Addendum No. 1

RE: Contract # C204071

Guilford County (U-5169)

I-74/US-311 And NC-68 (Eastchester Drive) Interchange Improvements

REVISIONS						SHEET NO.
NO.	BY	DATE	NO.	BY	DATE	SW-2
1			3			TOTAL SHEETS
2			4			6

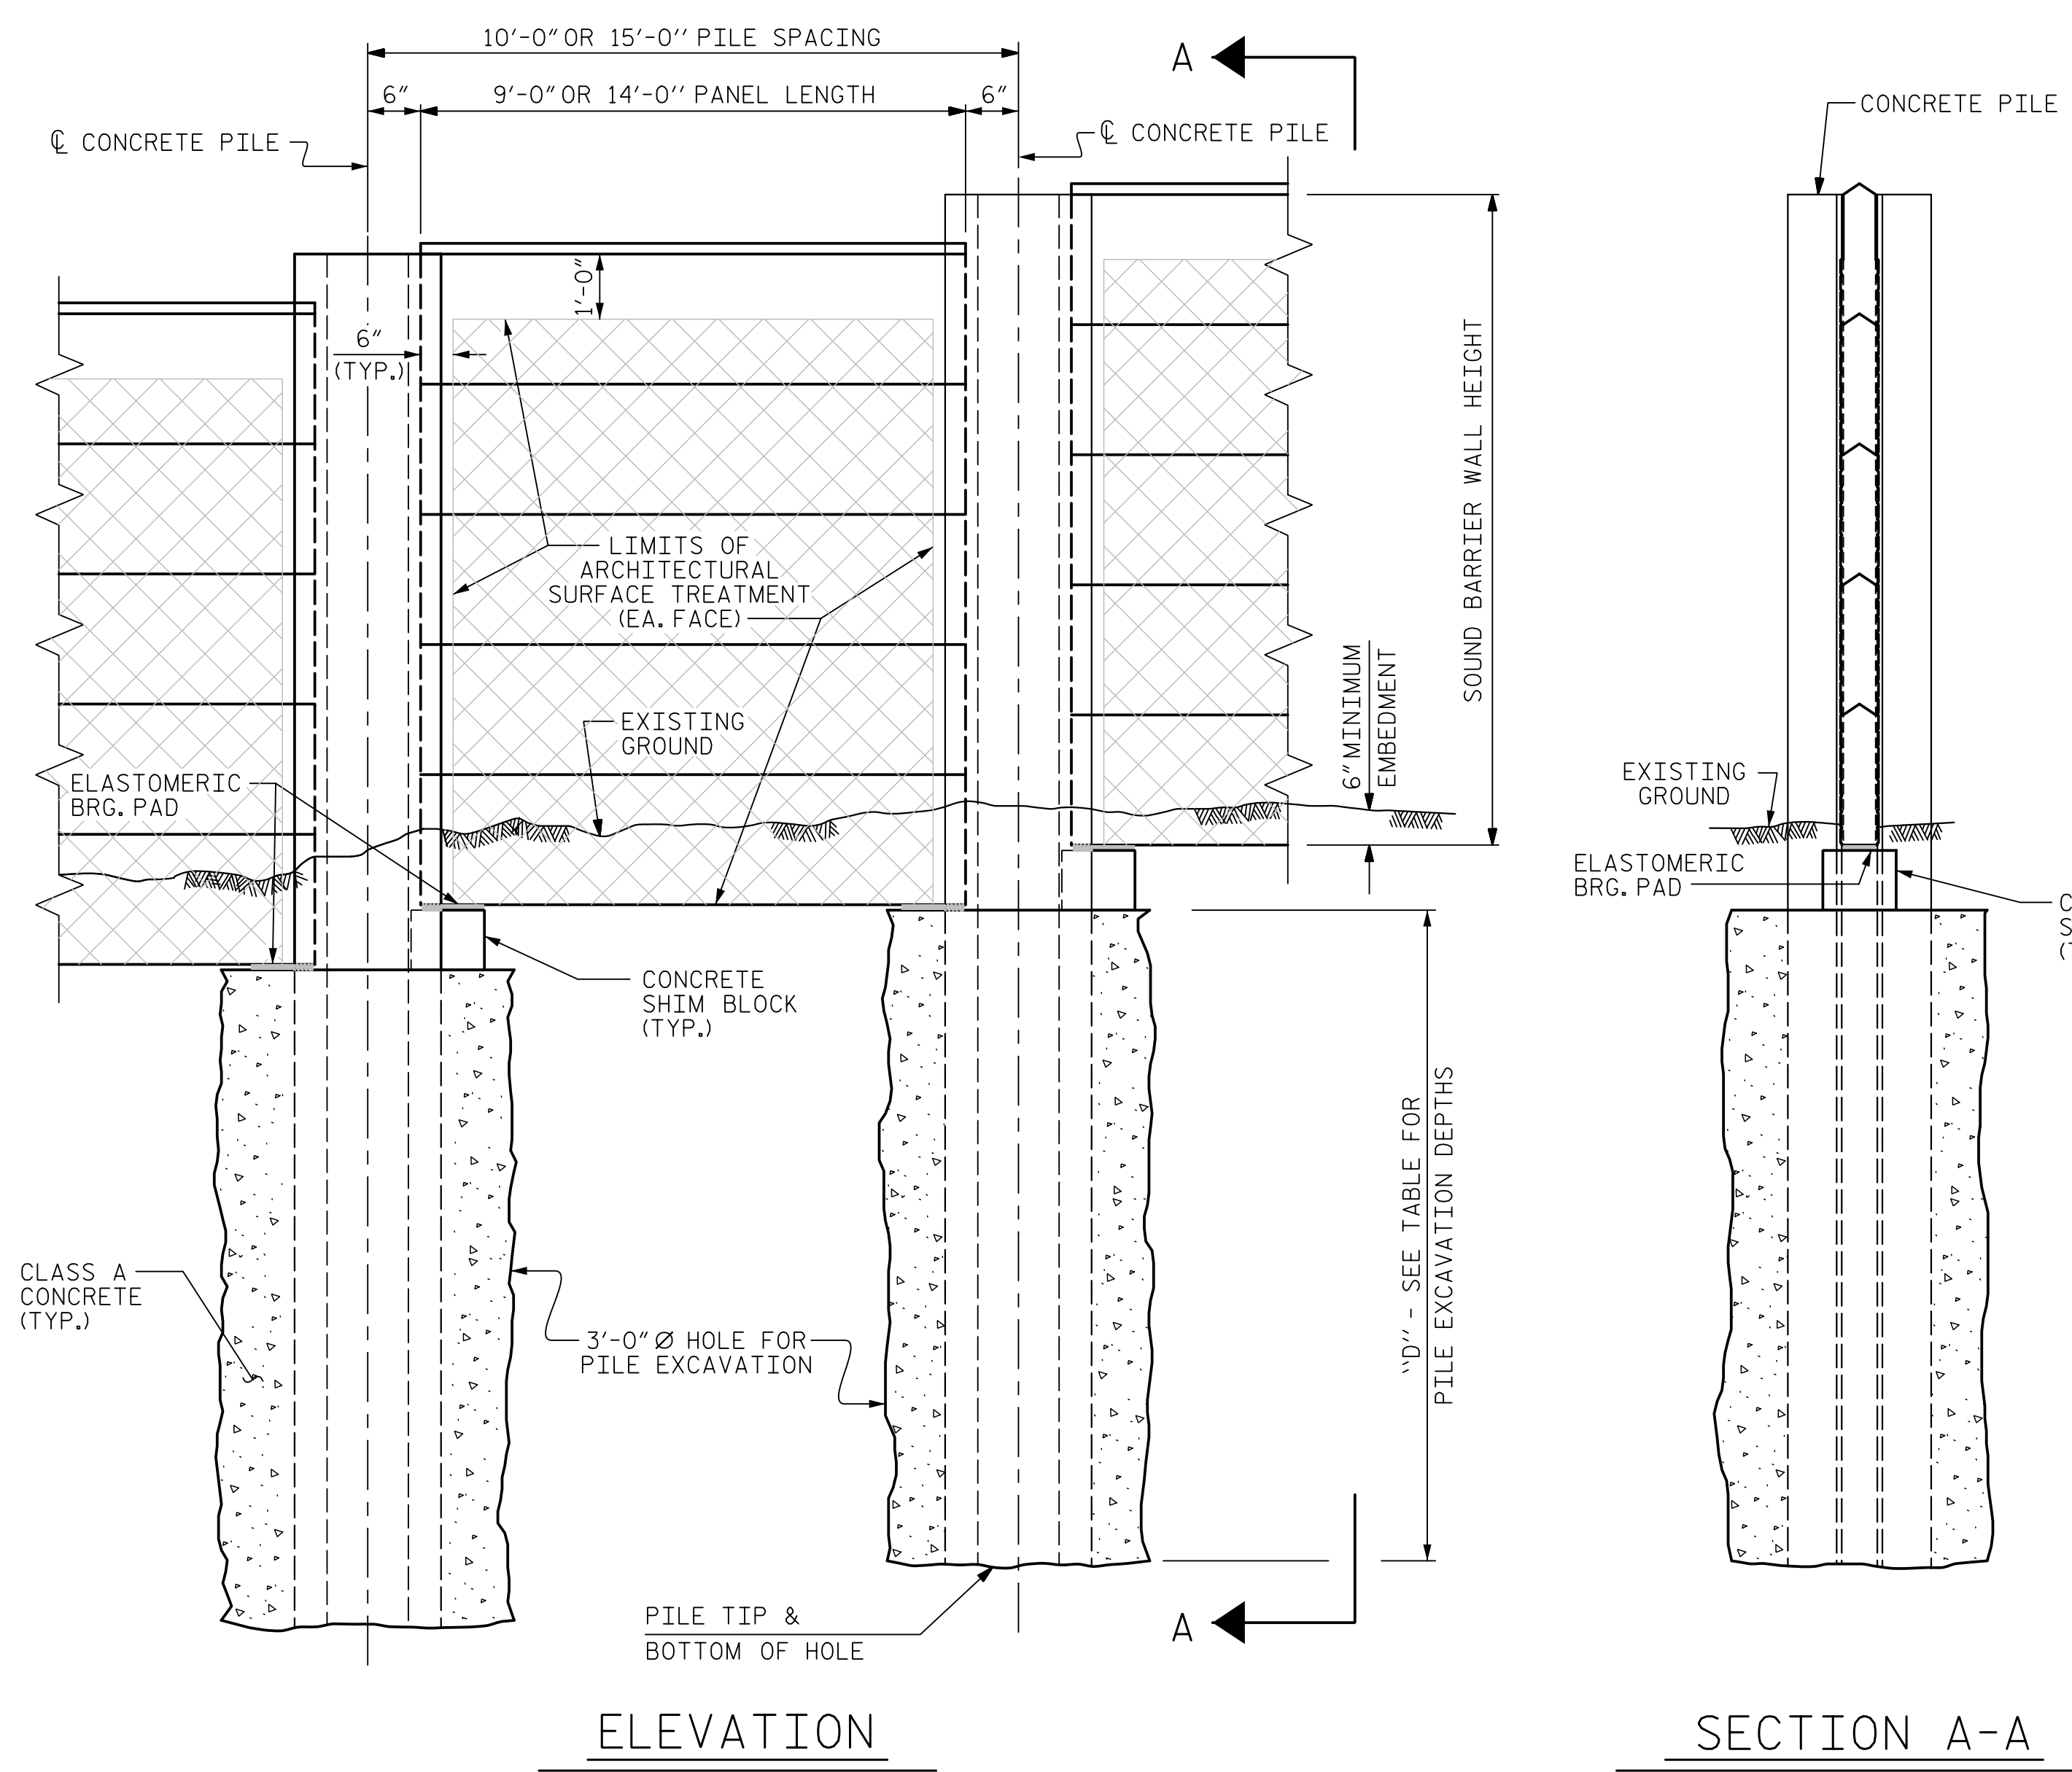
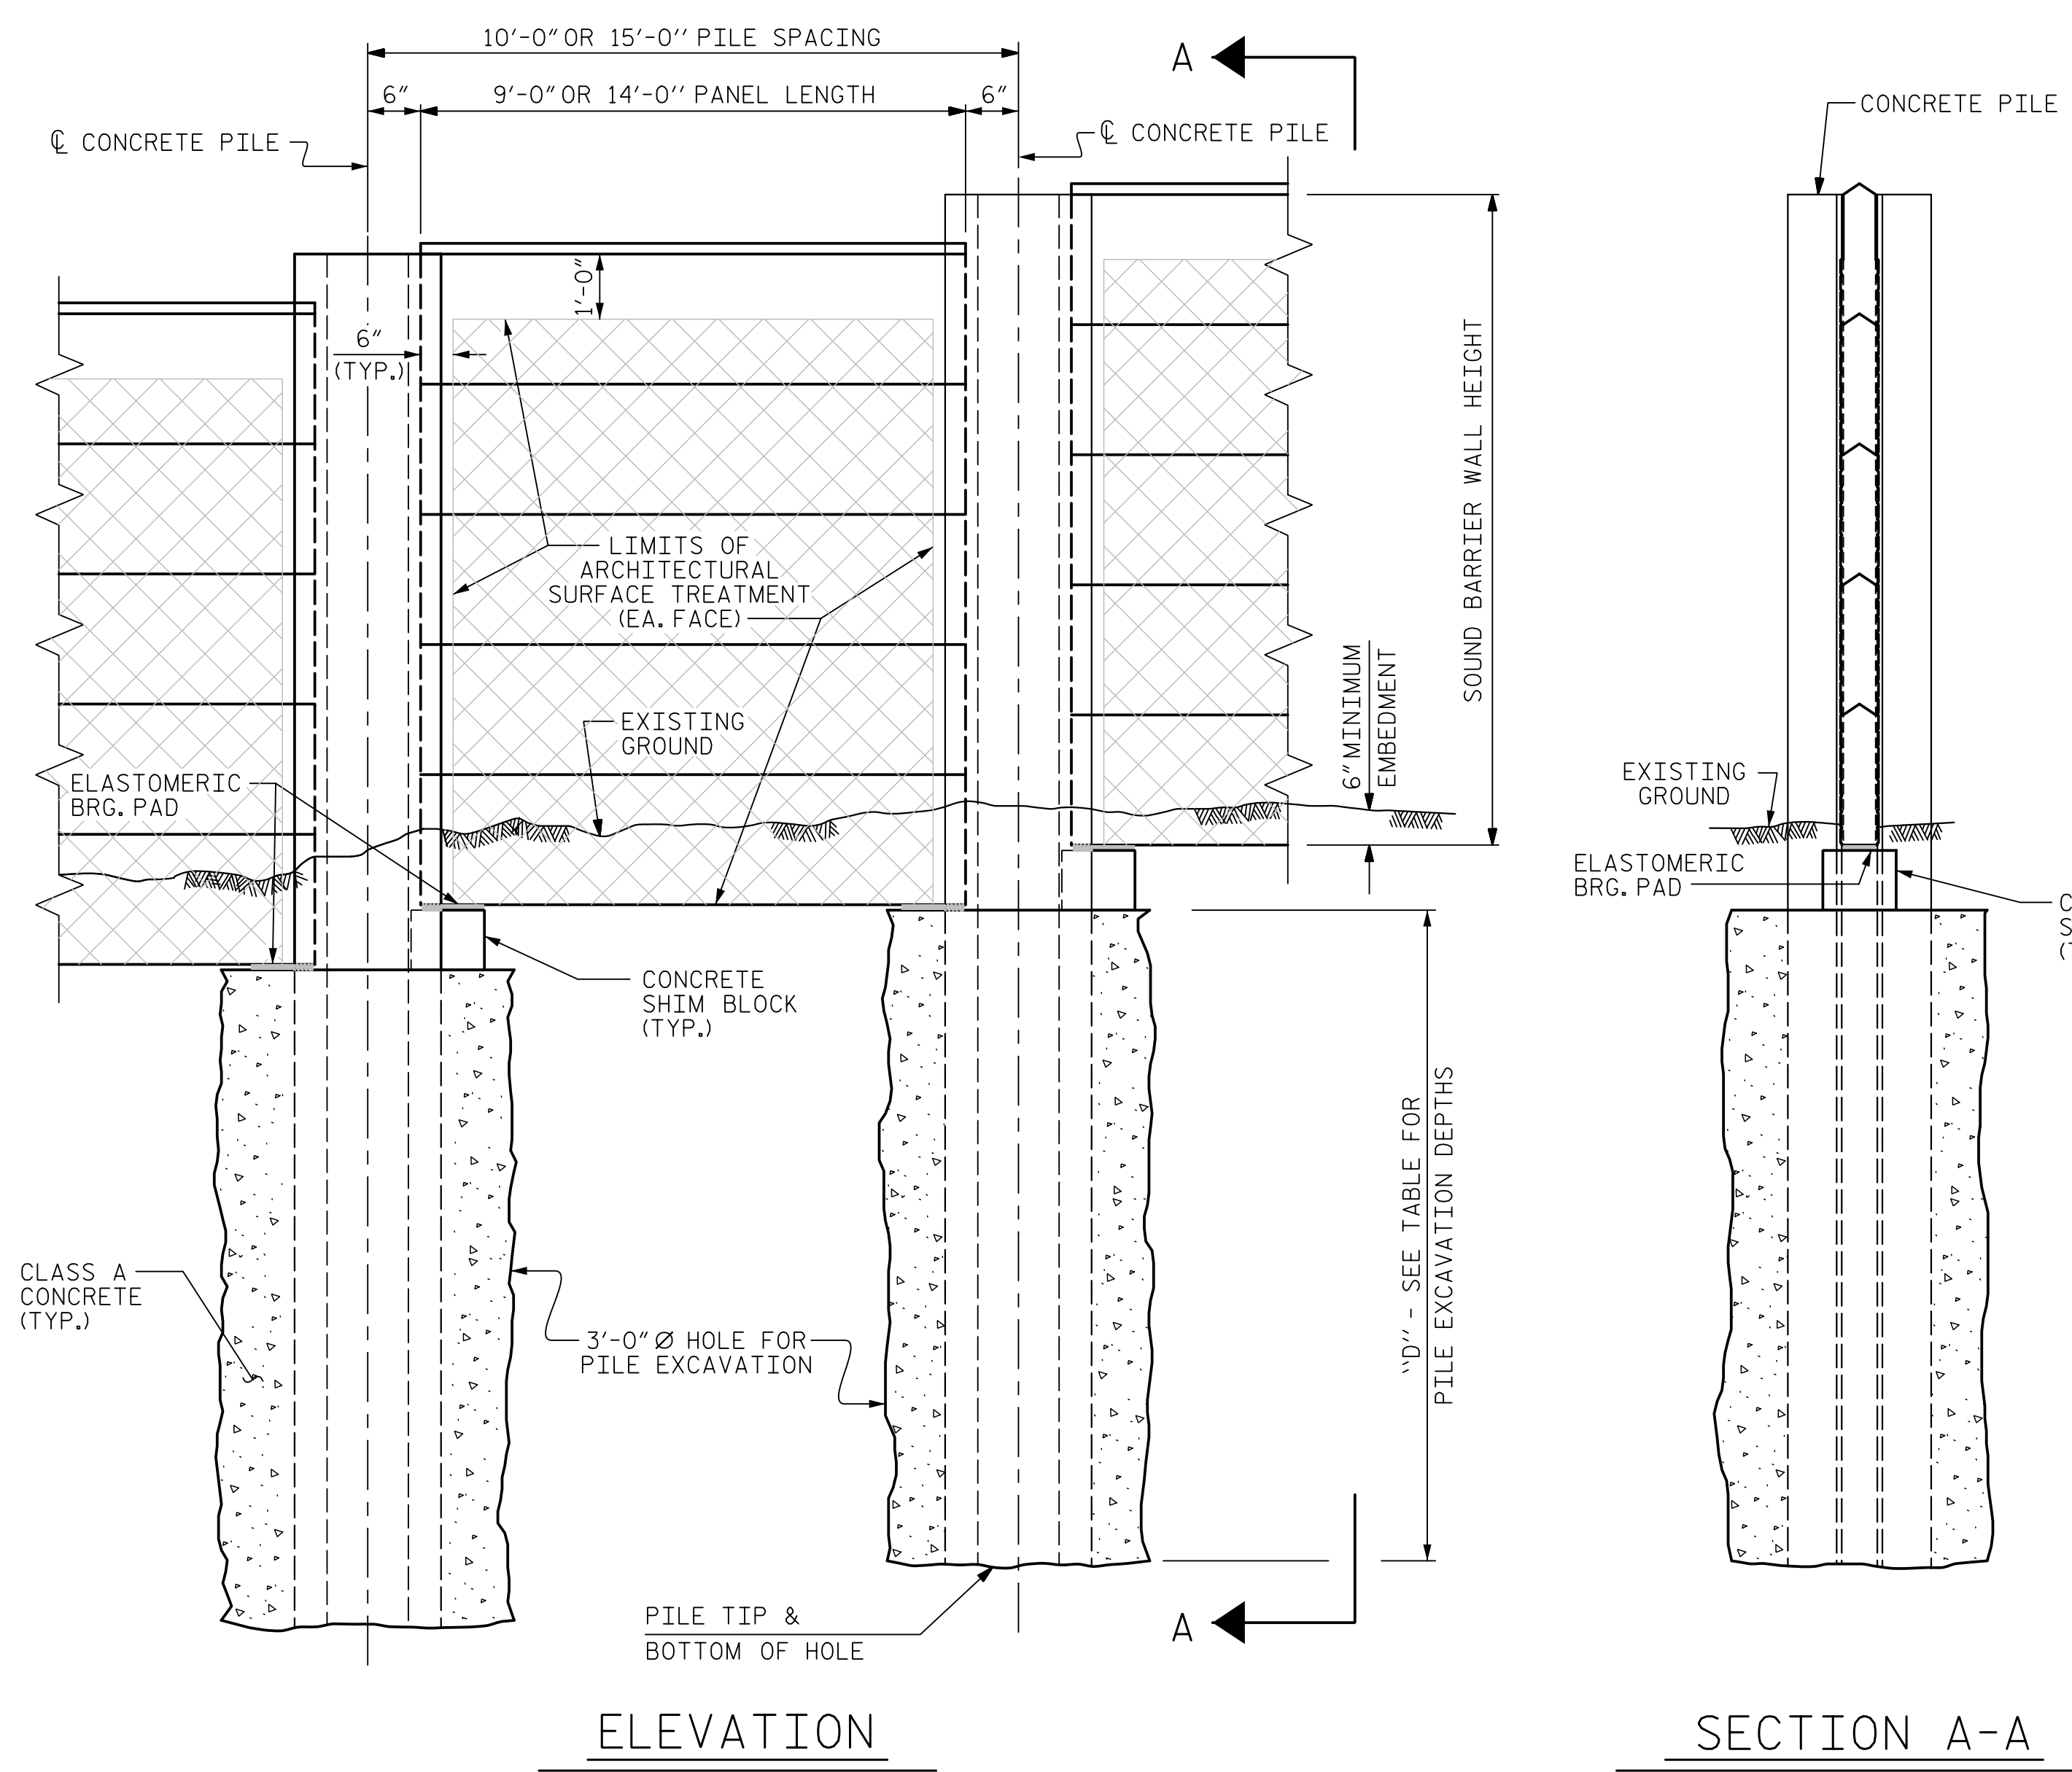
Sheet No.	Revisions
New Sheet Nos. SW-1 thru SW-6	New Sheets to add details for "Sound Barrier Walls"
